Subject: RE: Attached letter from Kirklees Council regarding application number 2023/90490 at location land south of, 5-25, Clay Well, Golcar, Huddersfield
Date: 20 February 2023 11:15:47

I would like to advise that condition 8 pertaining to retaining structures can not be discharged pending the satisfactory completion of technical approval process (via the submission of an AIP) for the design of building retaining walls at plots 4,5 and 13.

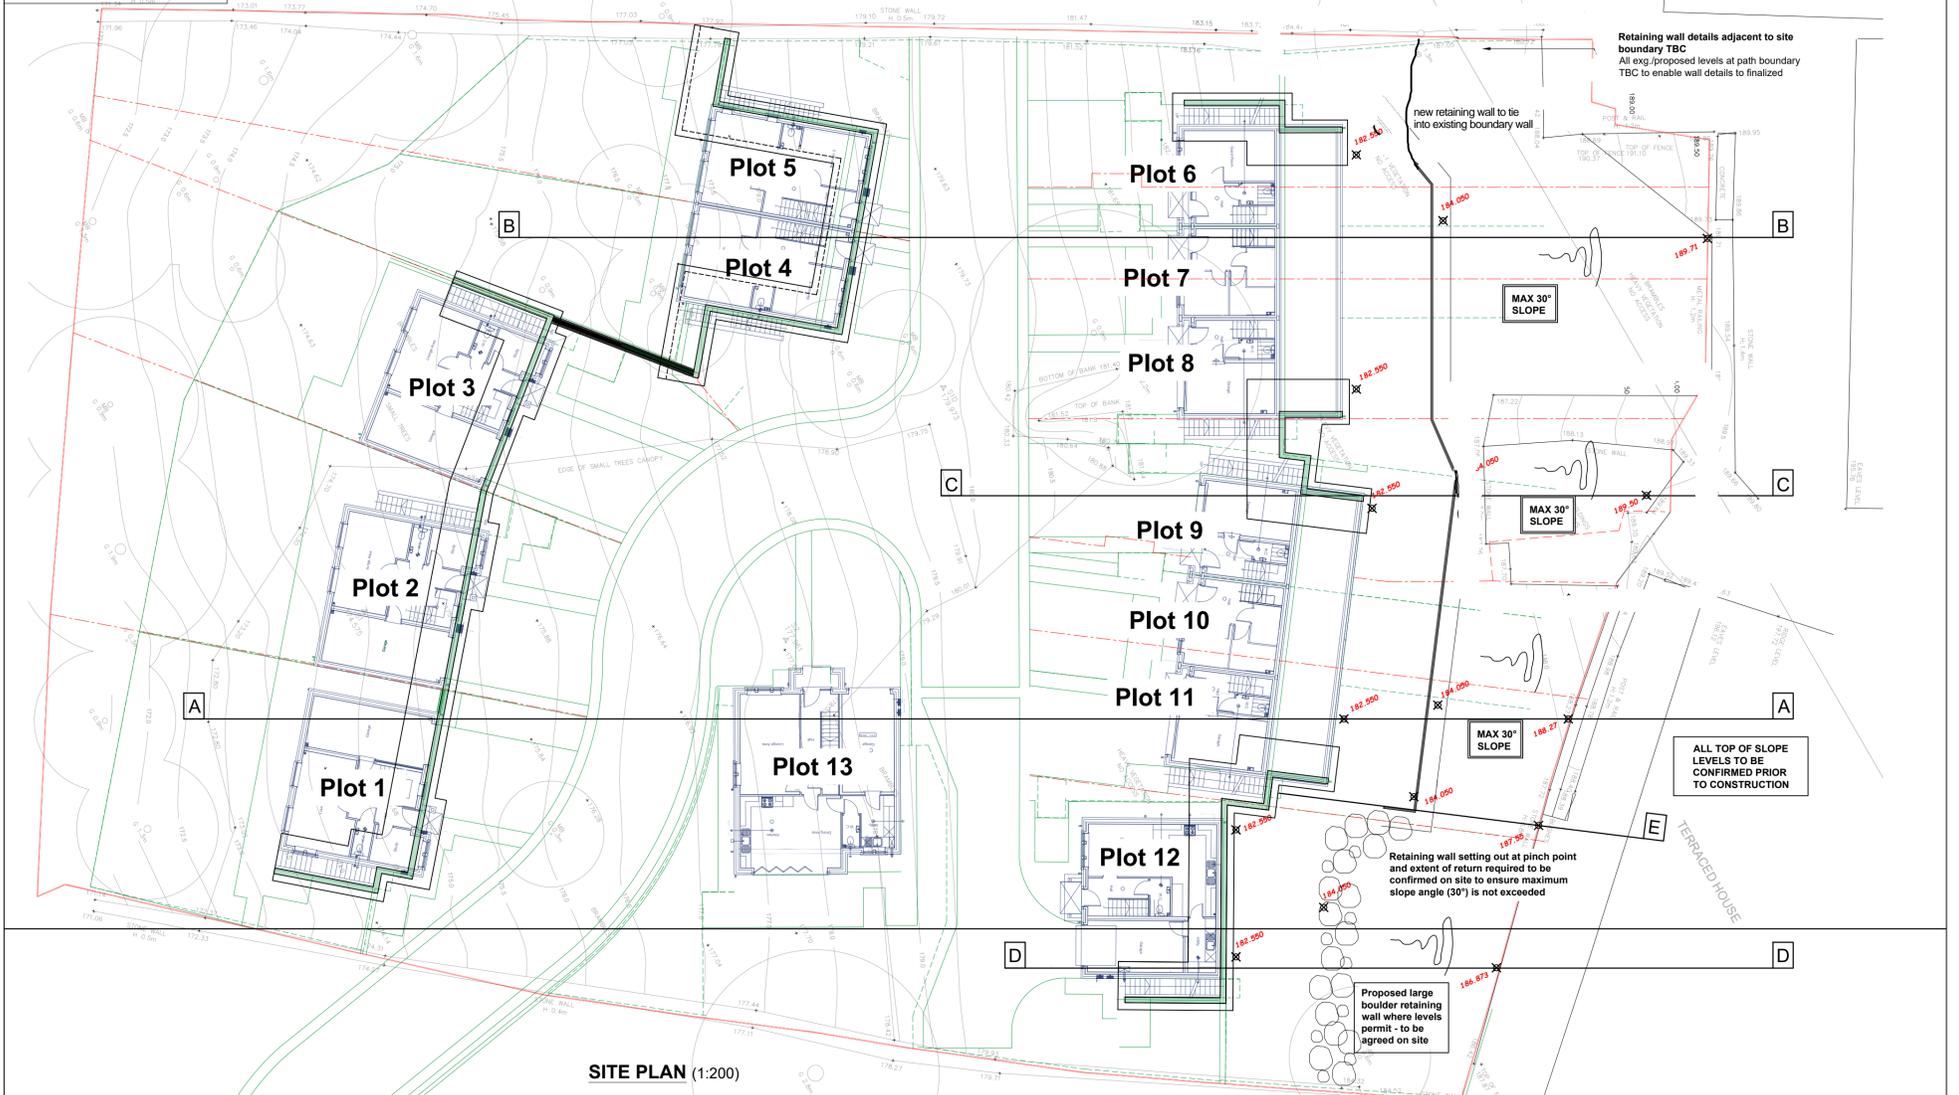
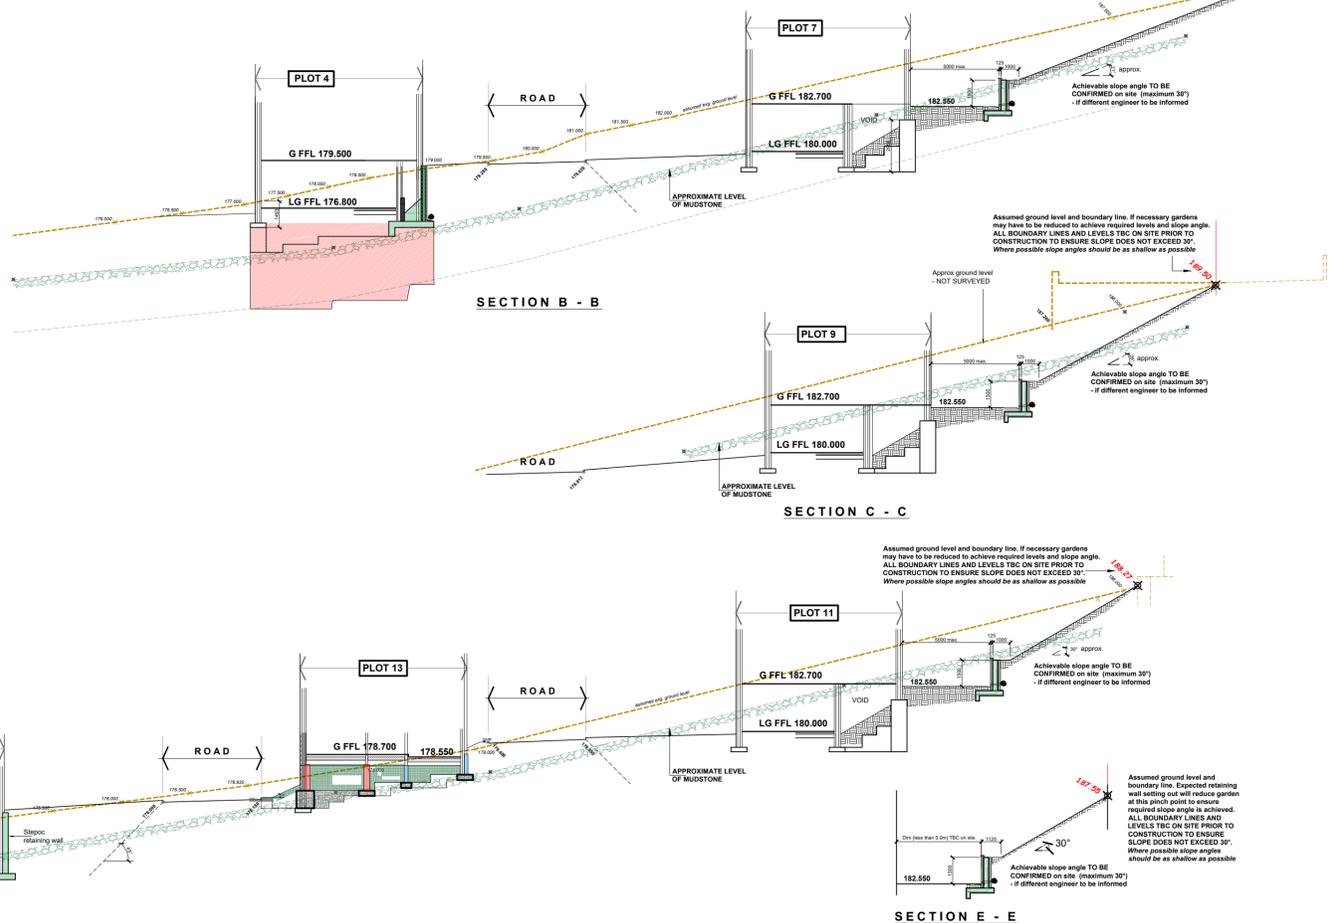
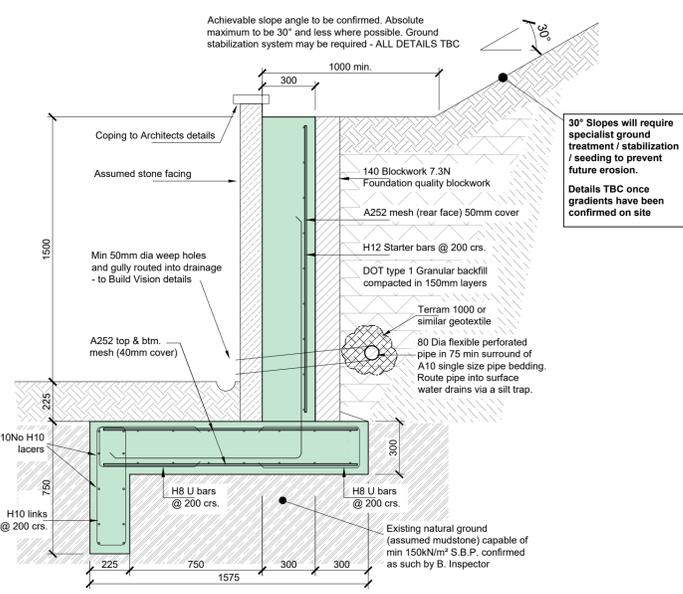
Furthermore, where is the location of retaining walls and gabions referred to in condition 23?
